Please ask for: Mrs D Johnson
Email: daun.johnson@arun.gov.uk
Telephone: 01903 737762
Our Ref: FG/129/21/PL
Your Ref:
Date: 28th July 2021

Application for Planning Permission

Development: Demolition of existing semi detached dwelling and erection of new detached dwelling. This site is in CIL Zone 4 and is CIL Liable as new dwelling.
Location: 2 The Poplars Ferring BN12 5QL

| 2    | Site Block Plan |

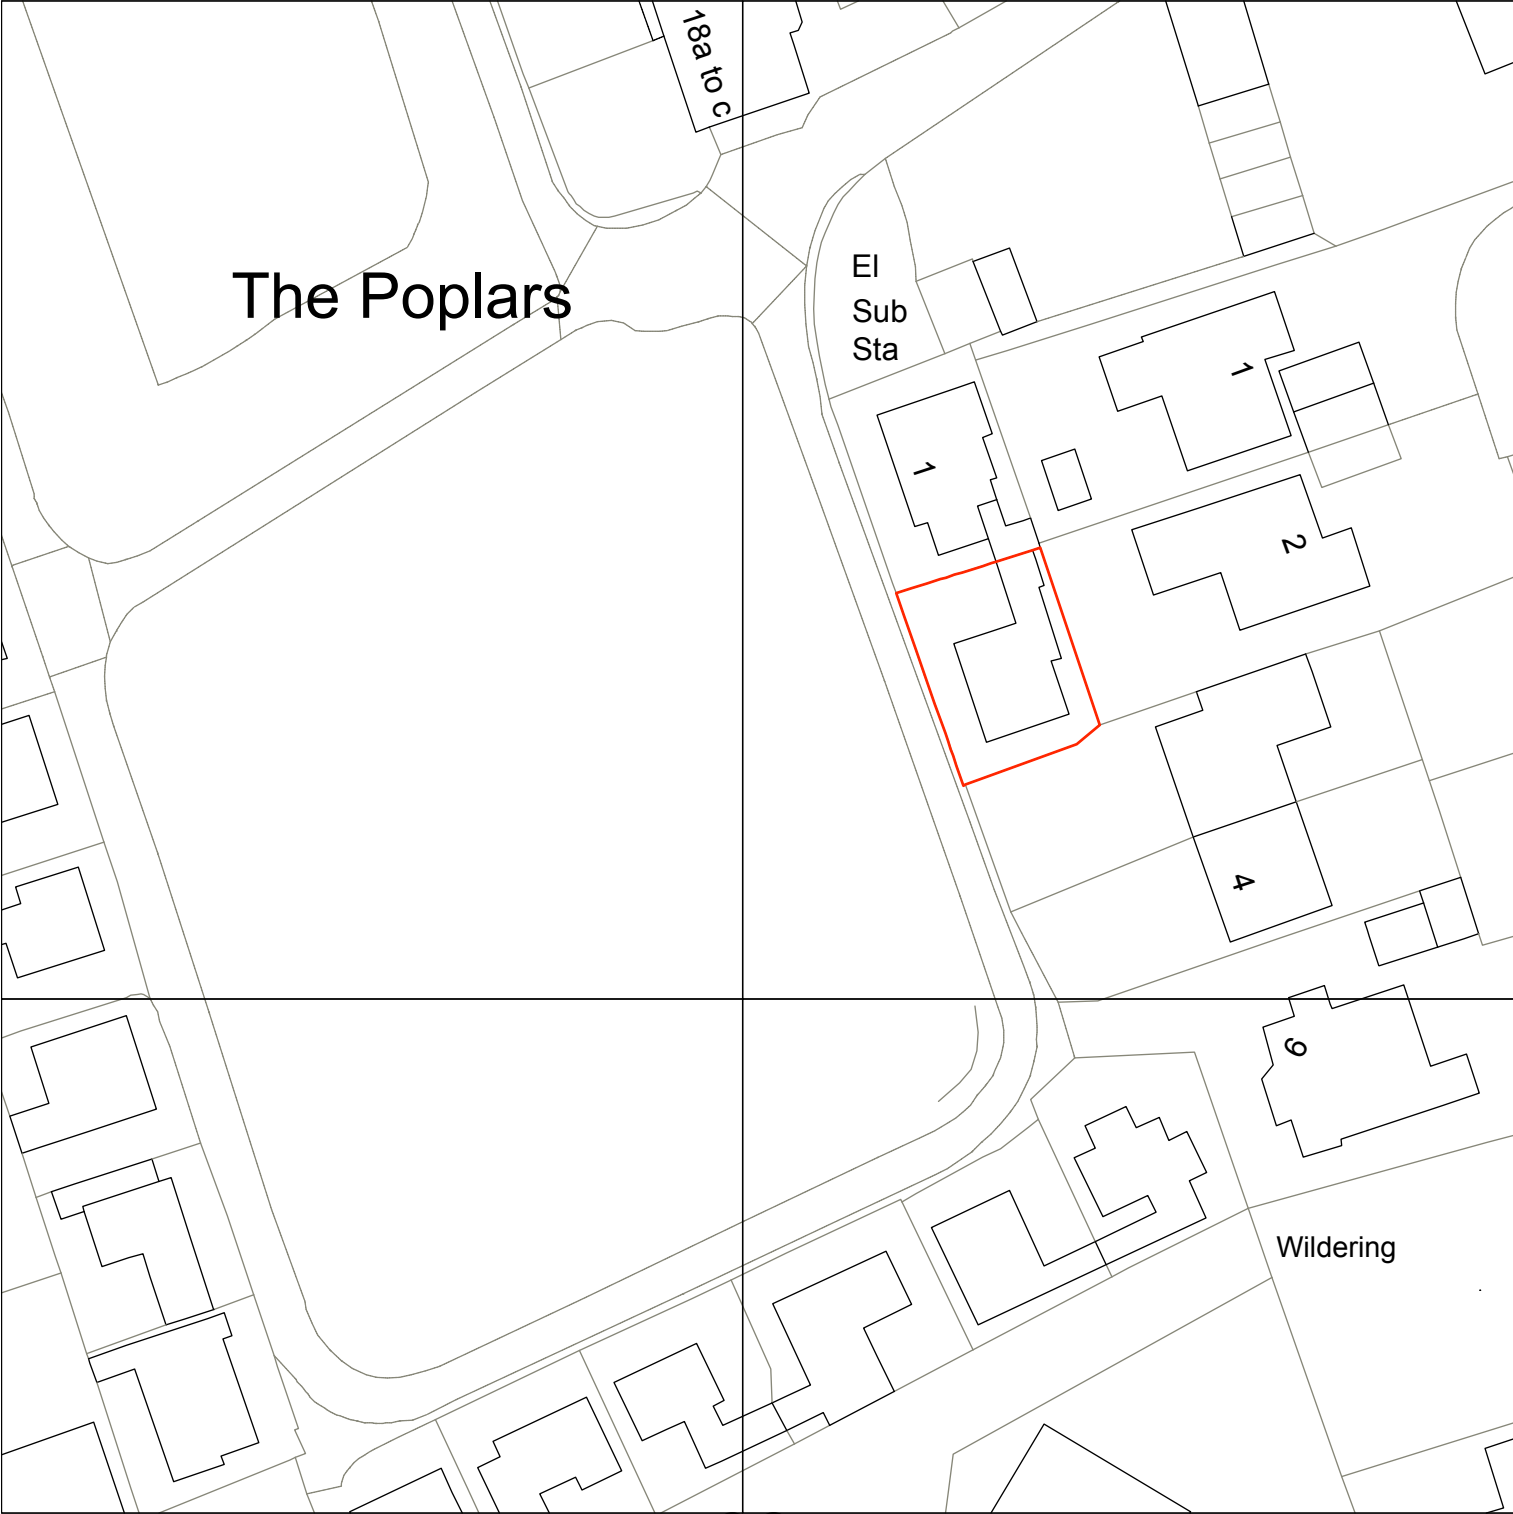
On the block plan, please show the position of the proposed new dwelling.

DRAWING TITLE
Block Plan Proposed

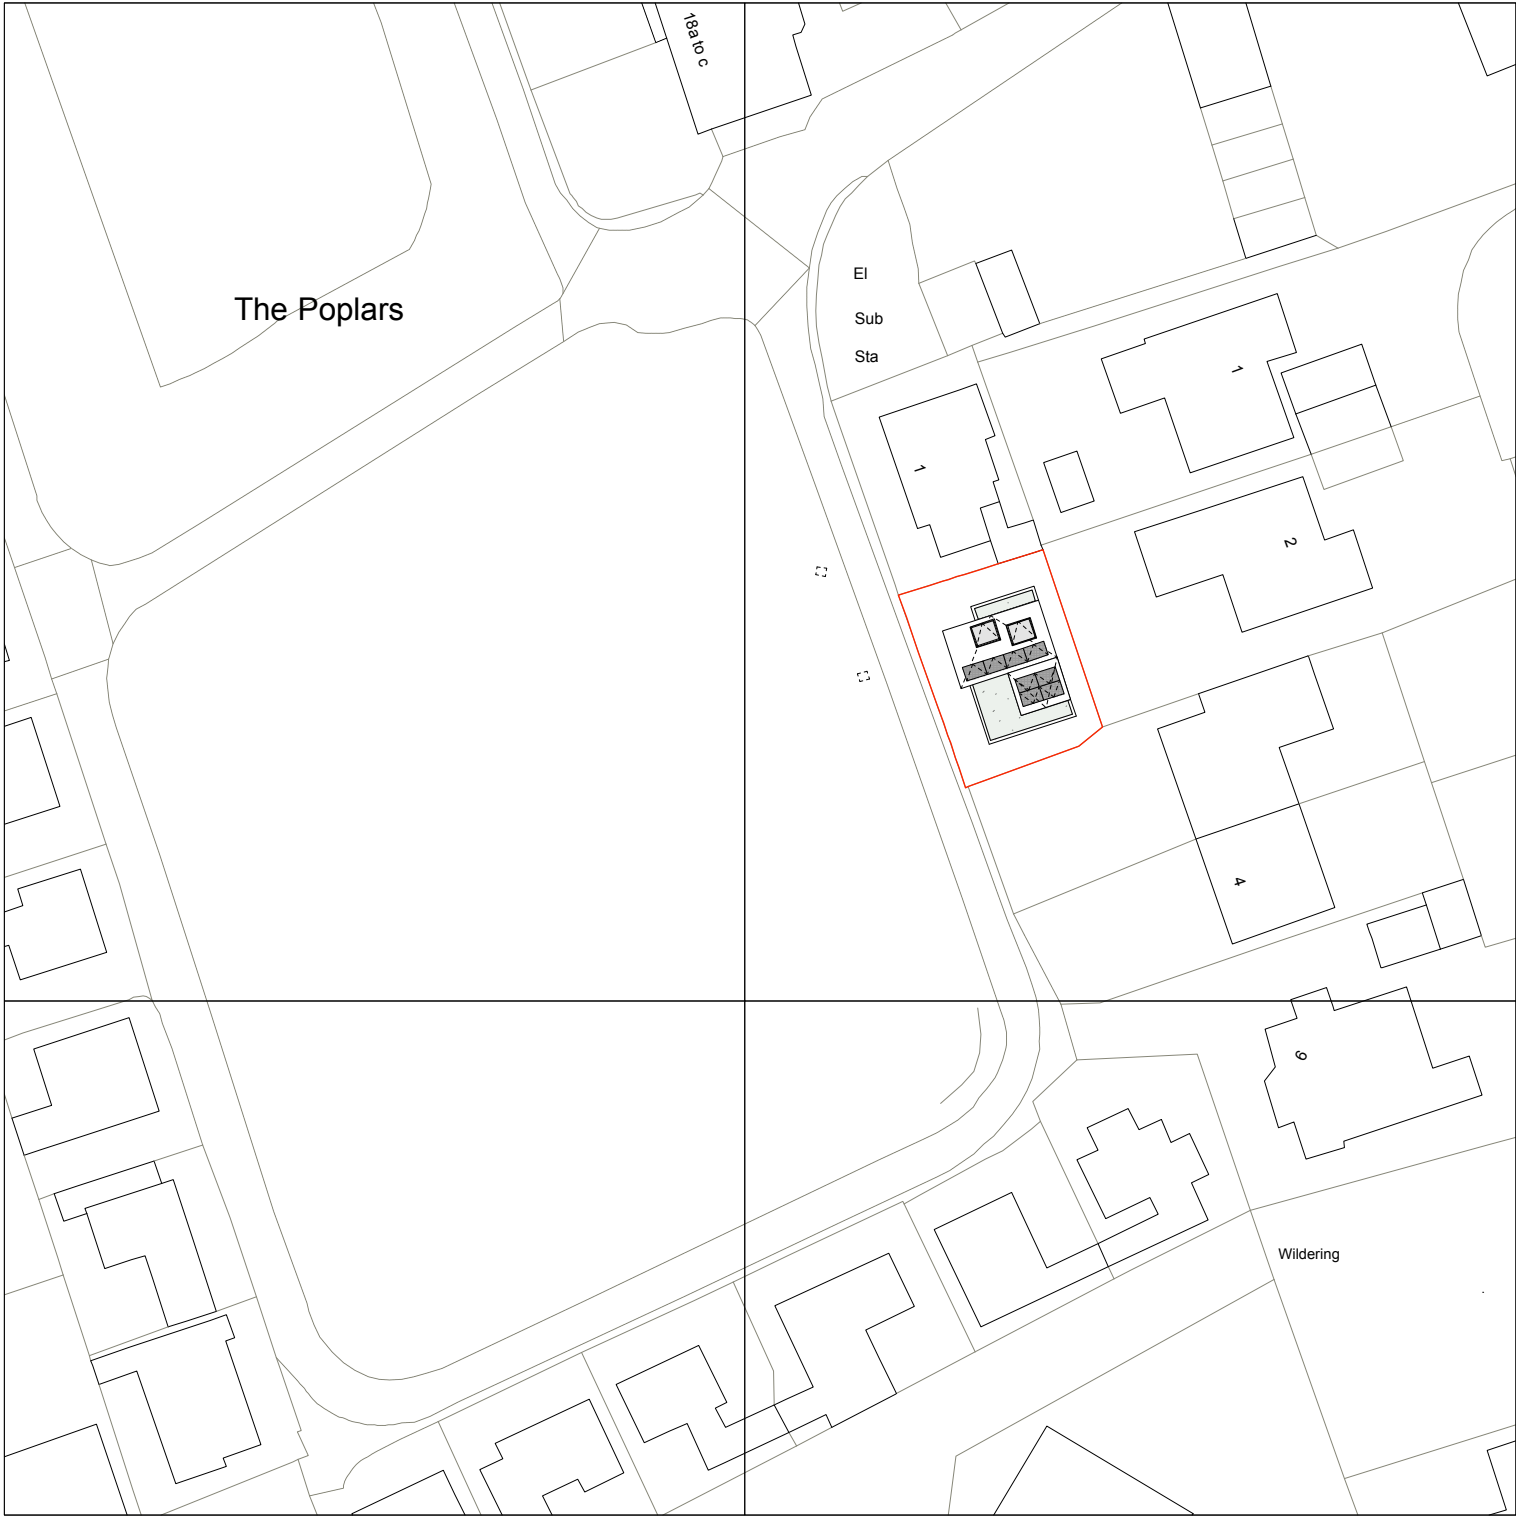
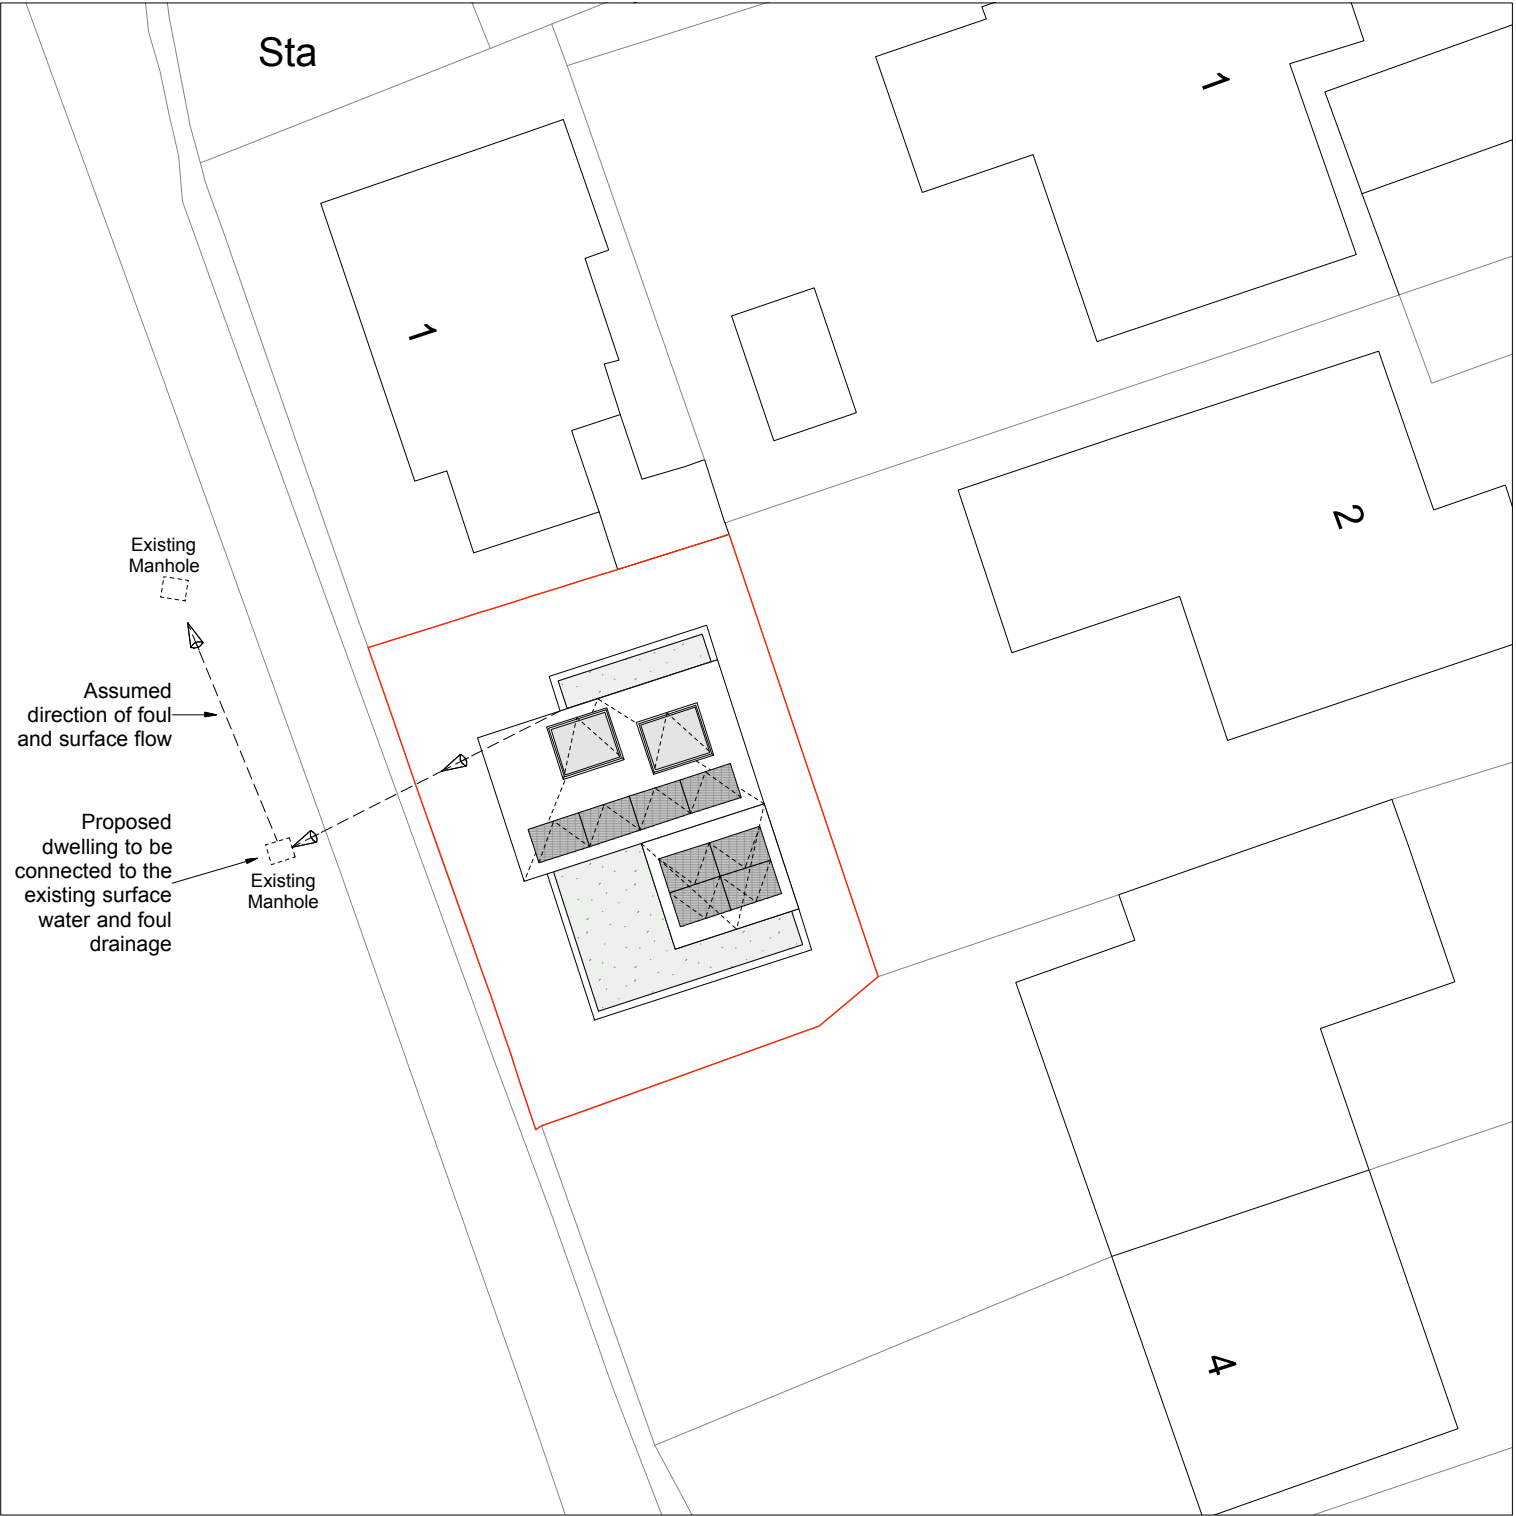
Please confirm how the foul water will be disposed.
